Reference No:	2023/62/90708/W
Site Address:	5, Leas Avenue, Netherthong, Holmfirth, HD9 3EP
Description:	Erection of two storey side extension and single storey rear extension, associated landscaping works and widening of existing driveway and alterations
Recommending Officer:	Lucy Taylor

Officer Report.

Reference: 2023/90708

REV.	DATE	DRN.	CHKD.
PROJECT			
5 Leas Avenue, Holmfirth			
CLIENT			
Ryan & Katie			
DRAWING			
Proposed Floor Plans			
SCALE	SHEET SIZE	DRAWN	CHECKED
1 : 100	@ A3	AH	CA
DATE		17.01.23

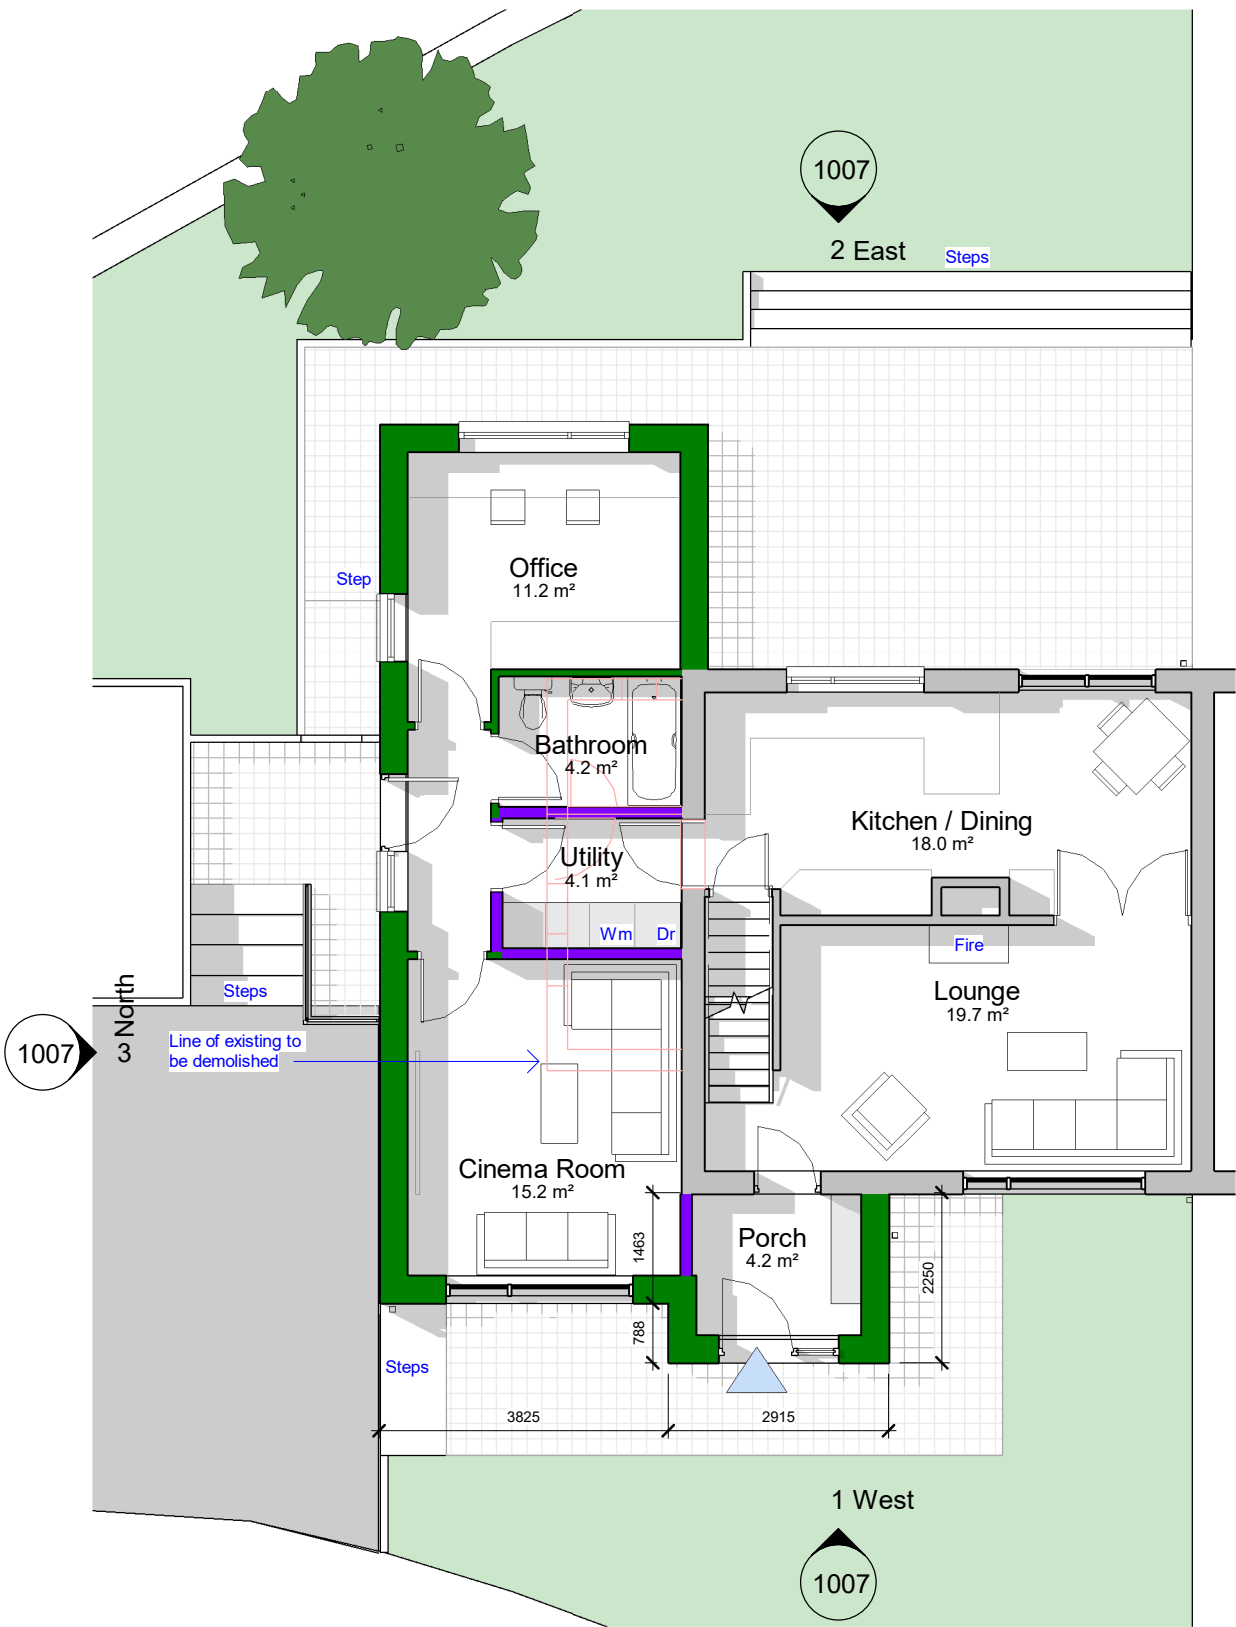
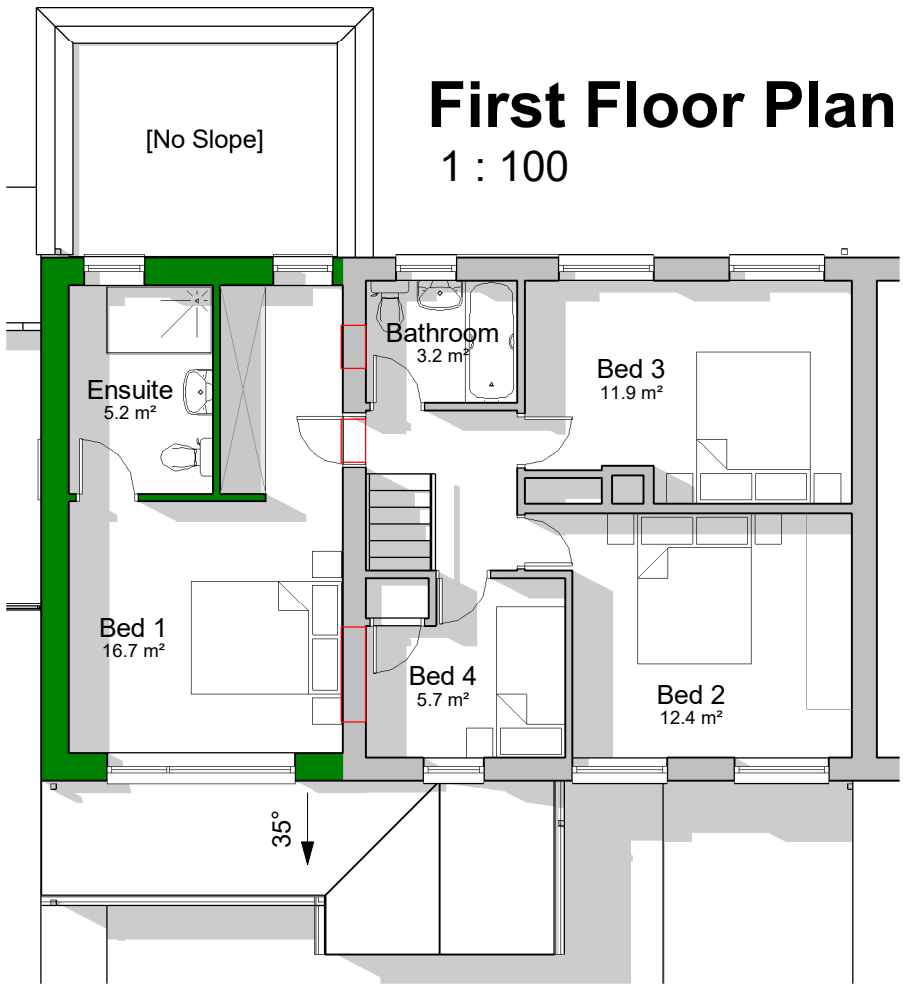
It is considered overlooking could occur were the flat roof extension to be used as a balcony / terrace. A condition is recommended to be included to ensure this roof is not used for such a purpose.

5. The flat roof of the single storey extension to rear hereby approved shall be used as a roof area only and shall not be used as a balcony or terrace area at any time throughout the lifetime of the development.

DRAWING
Proposed Elevations and Section

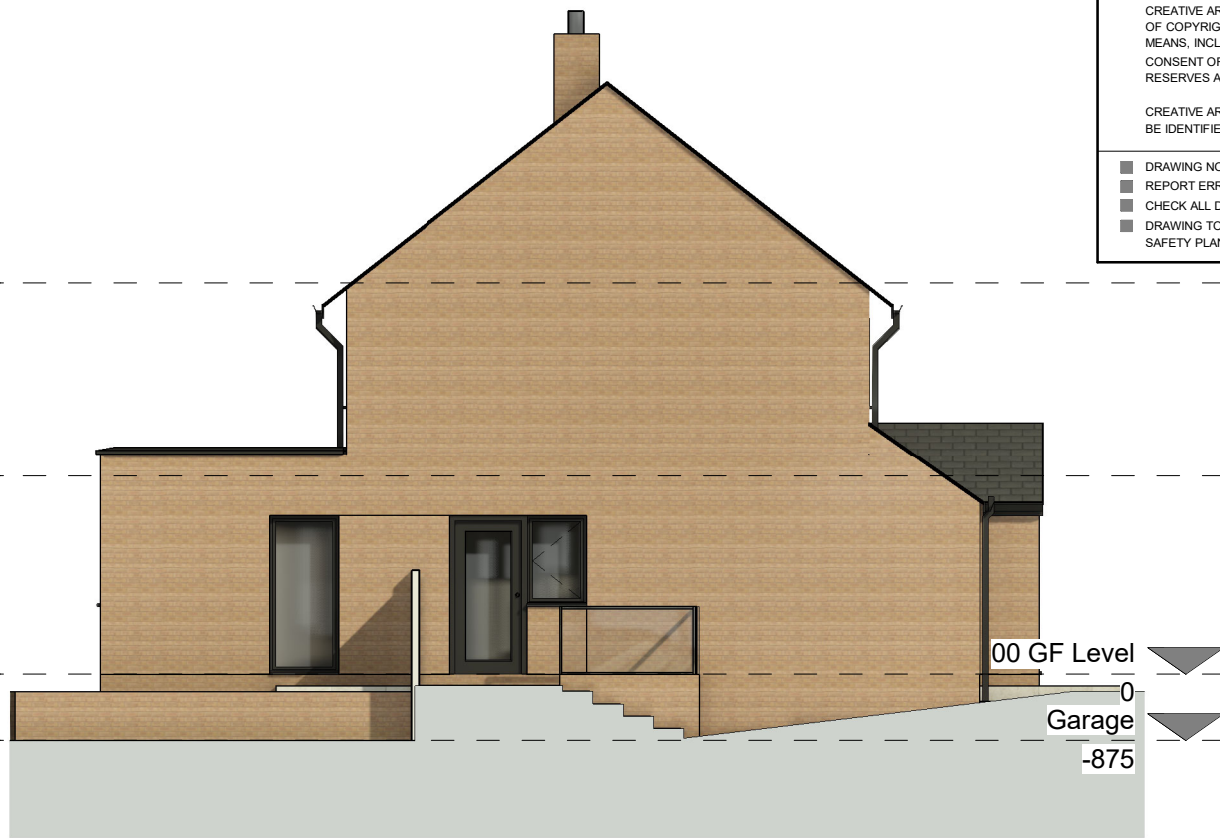
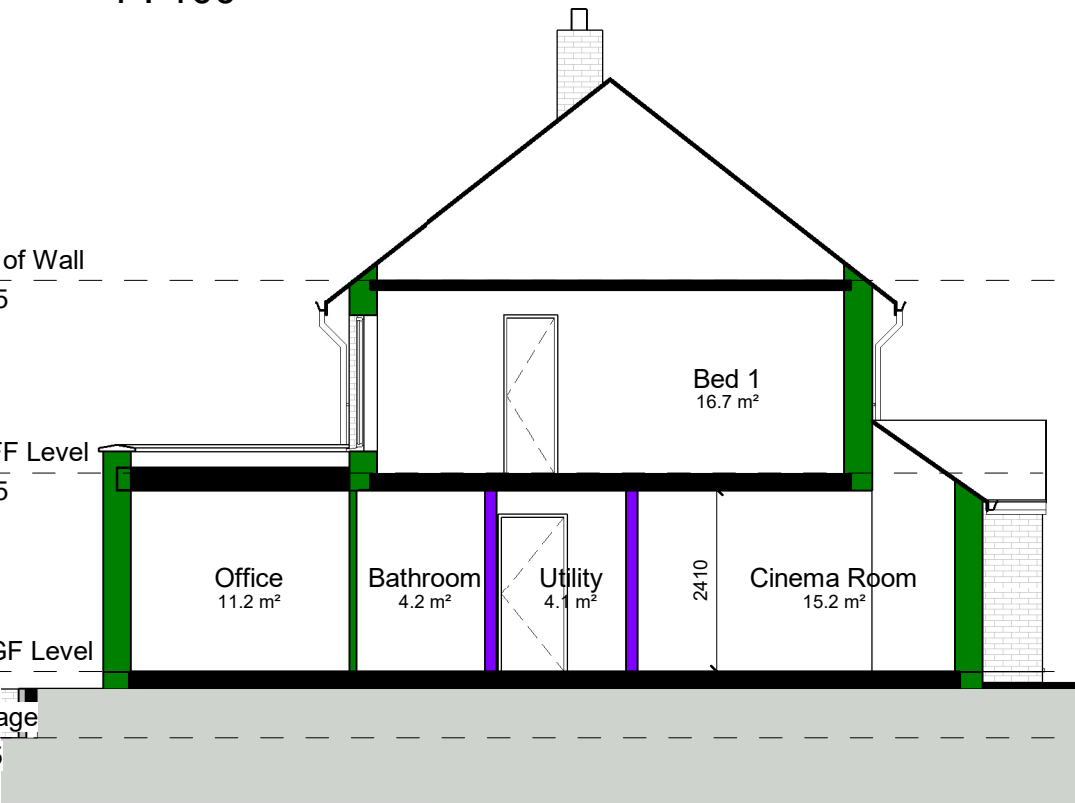
The proposed single storey rear extension to 5 Leas Avenue is considered to appropriately comply with the key design criterion of the SPD as set out above. The extension would not project out more than 3 metres and would not exceed a height of 4 metres. In turn, with regard to the size/scale of the proposed rear extension, it is considered that it would appear subservient to the host property, with a single storey height and faced in matching exterior construction materials. It could also be noted that, the use of a flat roof, by form, would also work to naturally reduce the potential for undue bulking or massing from the overall appearance of the extension.

The extension would retain a gap of 0.5 metres from the shared boundary with the adjoining neighbouring property. This separation distance is considered sufficient based on the merits of the application site, retaining an appropriate sense of space around the site.

The design of the proposal is such that a single storey extension is proposed to the front of 5 Leas Avenue. The size/scale of the proposal is such that, following the erection of the front extension, the original principal elevation would remain to be clearly read as such. The external walls of the front extension would be faced in brick to match the host property and the lean-to roof would be infilled with matching tiles. For these reasons, the proposed front extension would appear as subservient to the original dwellinghouse of 5 Leas Avenue. The single gable form of the extension would follow the architectural form of the host property.

The host property is set back from the fronting highway of Leas Avenue, meaning that the proposed front extension would also be set back (by minimum of approximately 4.65 metres). In addition, visibility of the proposed front extension would be well screened from public vantage points as a result of the forms of boundary treatment in place, tall hedging.

The proposed two-storey extension would extend 4.5 metres from the side elevation of the original dwellinghouse, measuring less than two thirds of the

width of the host property in accordance with the SPD. The enlargement would be faced in matching materials and would incorporate a gable roof finished in tiles to match the appearance of the host property. The extension would feature a lower ridge line and would be set back 0.5 metres from the principal elevation at both ground and first floor level, such that it would have some form of subservience to the original build. The properties extension would retain separation from all properties boundaries and would have an acceptable scale relative to the original build, maintaining a sense of space within the plot and not giving rise to any terracing effect.

DRAWING
Proposed Site Plan

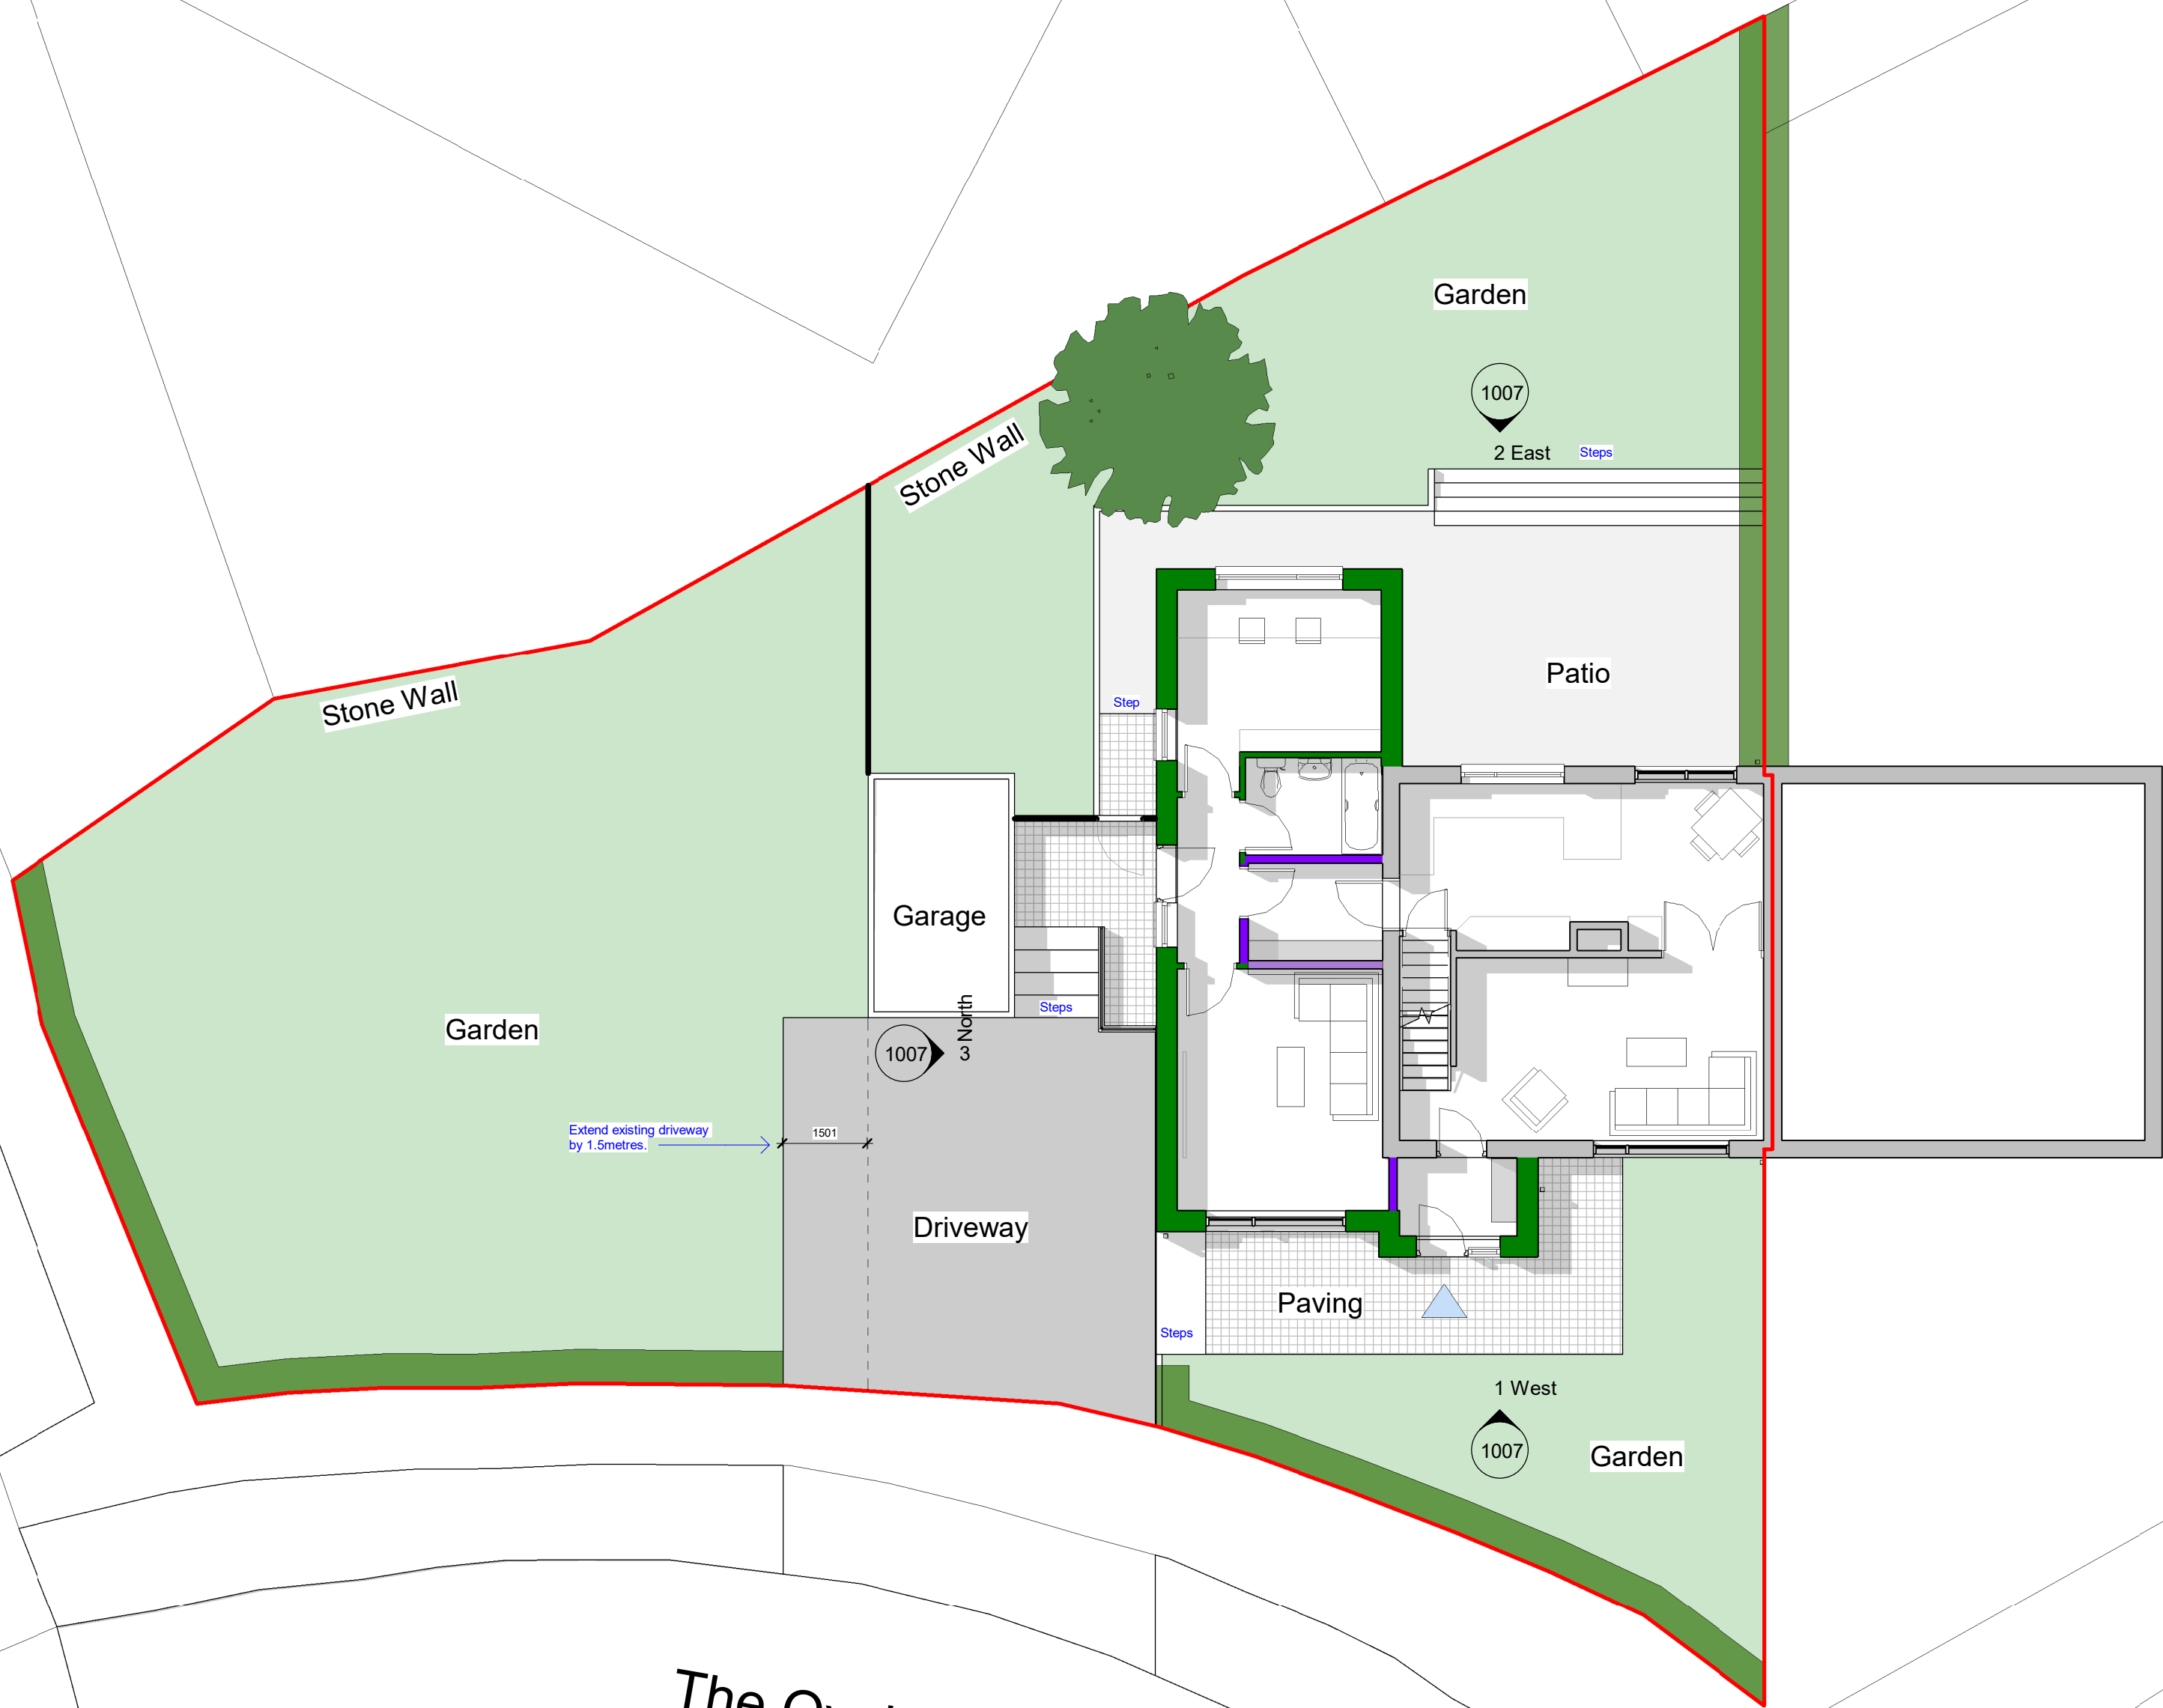
With regard to the widened driveway, upon any grant of approval, a condition is recommended to be imposed to ensure that the widened driveway be permeable.

4. The extensions hereby approved shall not be brought into use until the extended driveway as indicated on the hereby approved site plan (dwg no. 1005) has been laid out with a hardened and drained surface in accordance with the Communities and Local Government; and Environment Agency's 'Guidance on the permeable surfacing of front gardens (parking areas)' published 13th May 2009 (ISBN 9781409804864) as amended or any successor guidance; Notwithstanding the provisions of the Town and Country Planning (General Permitted Development) (England) Order 2015 as amended (or any Order revoking or re-enacting that Order) this shall be so retained, free of obstructions and available for parking.
